# KITTITAS COUNTY COMMUNITY DEVELOPMENT SERVICES

August 27, 2021

**Subject: Forest Ridge (LPF-21-00006) Final Long Plat Ph 2 – Return of Application and Request for Additional Information**

FOREST RIDGE - PHASE II PERFORMANCE BASED CLUSTER PLAT		APR 3 8 2021	
FOR USE PERmits		KITITAS COUNTY	
A PORTION OF SECTION 24, TOWNSHIP 20 NORTH, RANGE 15 EAST, W.M.		DATE	04/20/21
DIVN BY	T.S.	SCALE	N/A
CHKD BY	M.I.K./D.L.P.	SHEET	1 OF 5
JOB NO.	18069

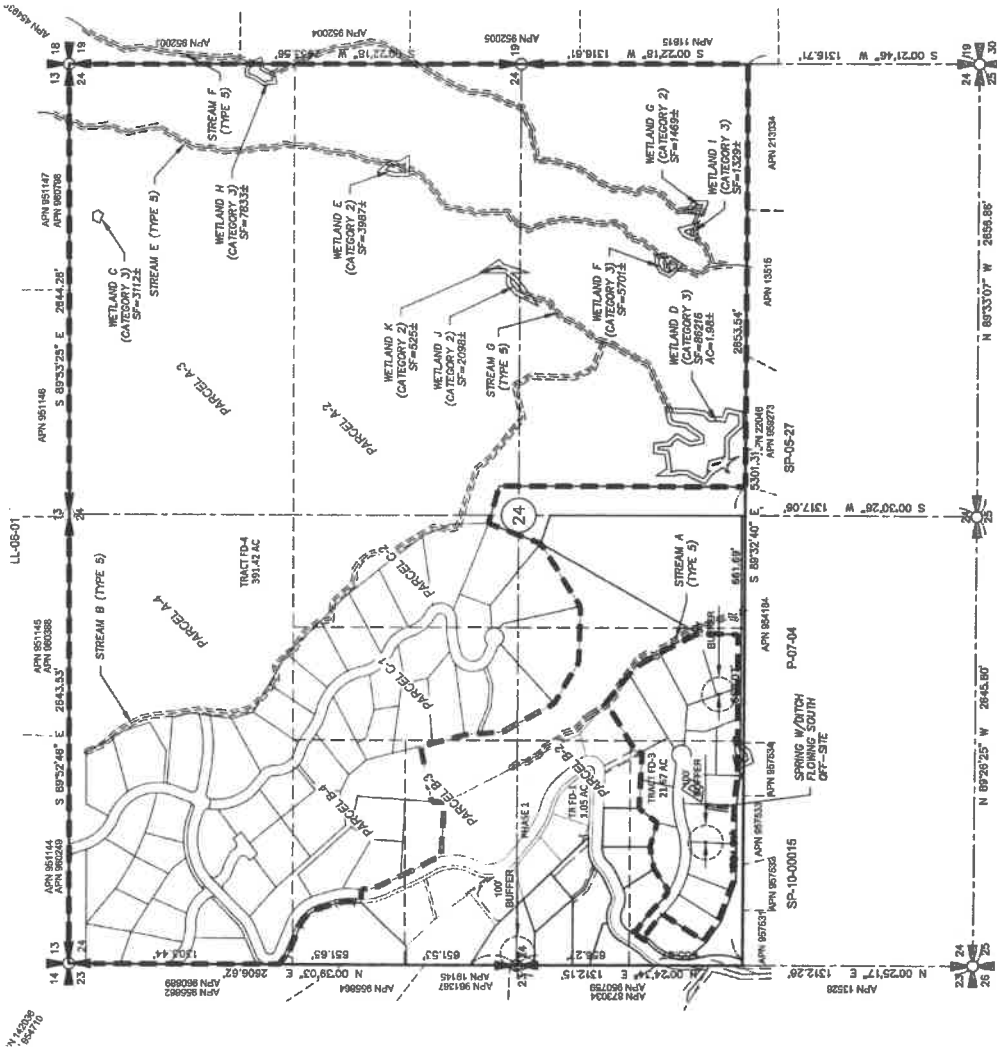
- Condition #7 of the associated SEPA MDNS requires that snow removal areas be indicated on Final Mylars. CDS could not locate these areas on the surveys submitted.
